**Consultation Response from KC,
Ecology Unit**

2022/91477 Land off Lindley Moor Road, Lindley, Huddersfield, HD3 3SX

Hybrid Planning Application for the erection of an industrial unit for E(g)/B2 /B8 use with associated access, parking, groundworks and landscaping in conjunction with an outline application for mixed use development use class E(a), E(b), E(g), B2 and B8

Date Responded: 04/04/2023

Project Name: Lindley Moor Road	Drawn: TH	Checked: MB	<b>FOR PLANNING</b>		
Drawing Name: Landscape Masterplan	Date: April 2022		E	MB	07.09.2023
Drawing No: DR-4823-01	Scale: 1:500 at A0		D	TH	27.09.2022
			C	TH	24.05.2022
			Rev	Drawn	Date

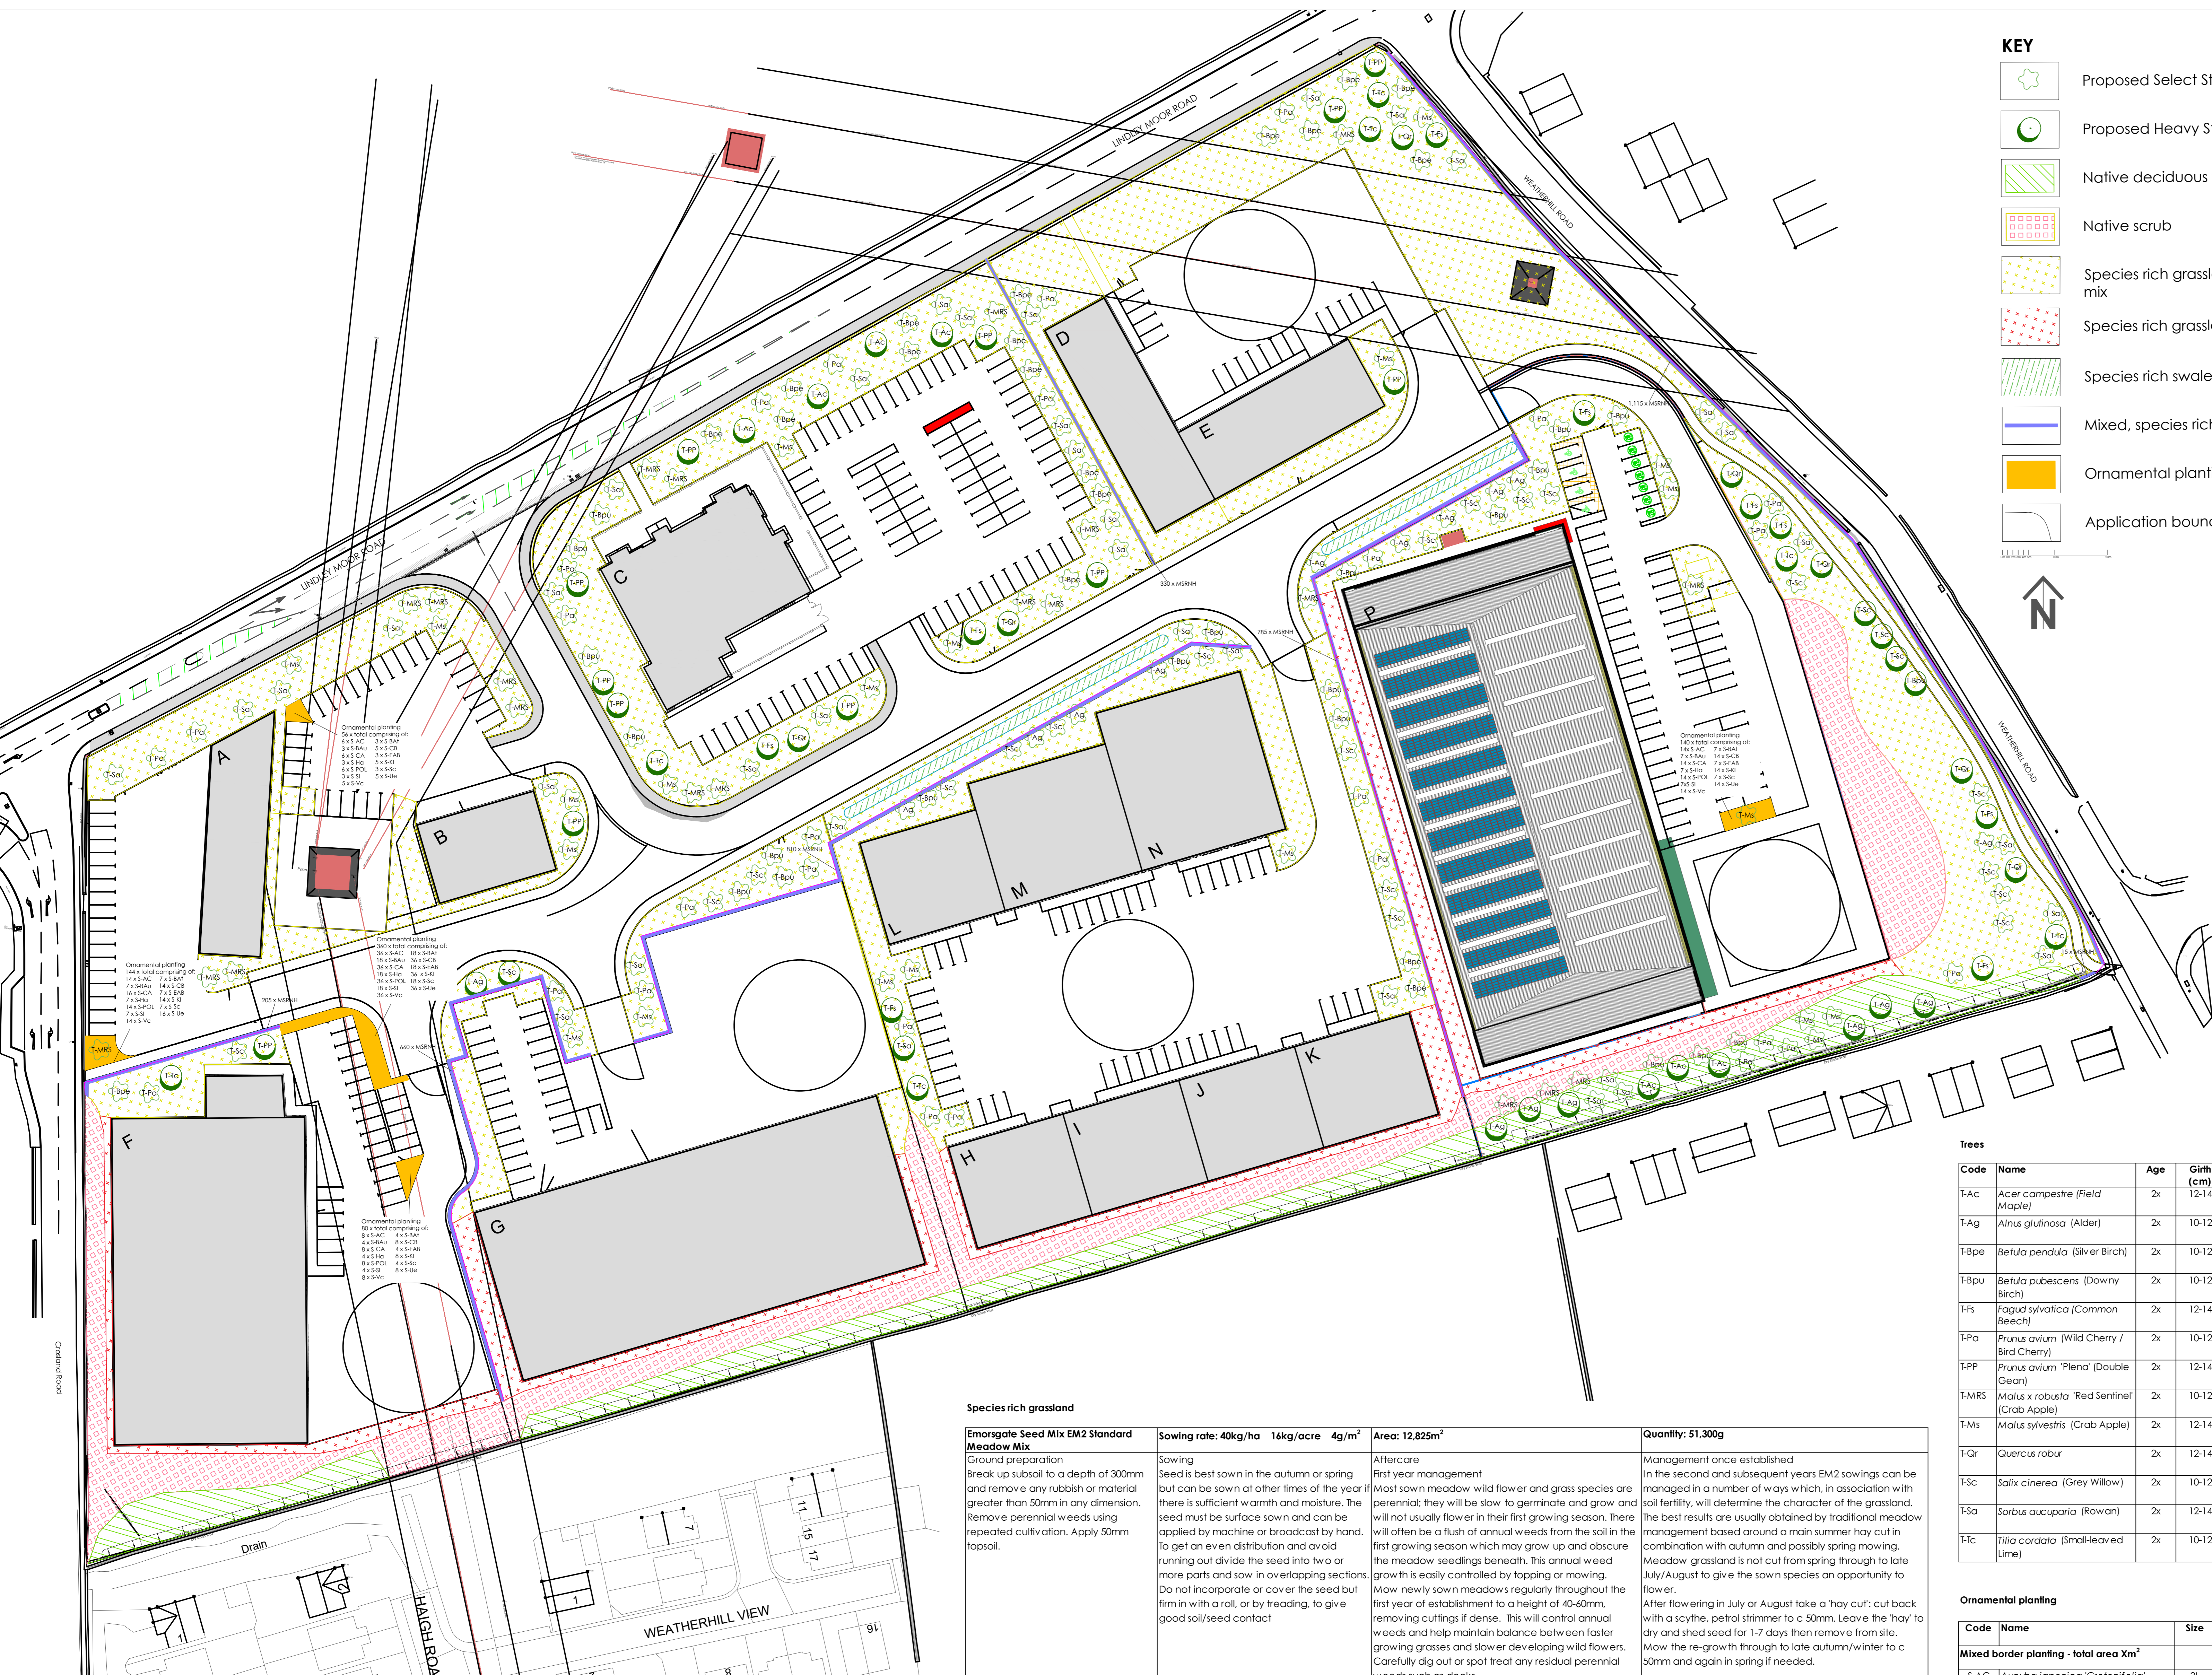
Following on from my previous comments, an updated Ecological Impact Assessment (EclA) and Biodiversity Net Gain calculation have been submitted with the application, in line with the updated landscaping plans. The submitted reports provide a comprehensive assessment of the site and lay out the potential impacts on ecological receptors, brought about by the proposed development. Overall, the site is of limited ecological value, comprising of species poor modified grassland with limited opportunities for protected species, given the intense grazing regime currently undertaken at the site.

An updated Biodiversity Net Gain calculation has been submitted with the EclA, using the Biodiversity Metric 2.0 calculator tool. The submitted metric details that there will be an overall **net gain** of 0.56 habitat units at the site (4.36% net gain) and a **net gain** of 2.14 hedgerow units (335.89% net gain). Although the net gain for both habitat types is welcomed, in order for the proposals to come forward in line with national and local policies and guidance, in order for the development to achieve a 10% net gain, 0.73 habitat units will need to be delivered, via off-site compensation. In line with the [Kirklees Biodiversity Net Gain Technical Advice Note](#), off-site compensation can be secured through one, or a combination of, the following:

1. No development shall commence until a Biodiversity Enhancement and Management Plan (BEMP). The plan shall demonstrate how a minimum of 13.52 habitat units and 2.78 hedgerow units are to be achieved post-development and include details of the following:
 - a. Description and evaluation of features to be managed and enhanced;
 - b. Extent and location/area of proposed enhancement works on appropriate scale maps and plans;
 - c. Ecological trends and constraints on site that might influence management;
 - d. Aims and Objectives of management;
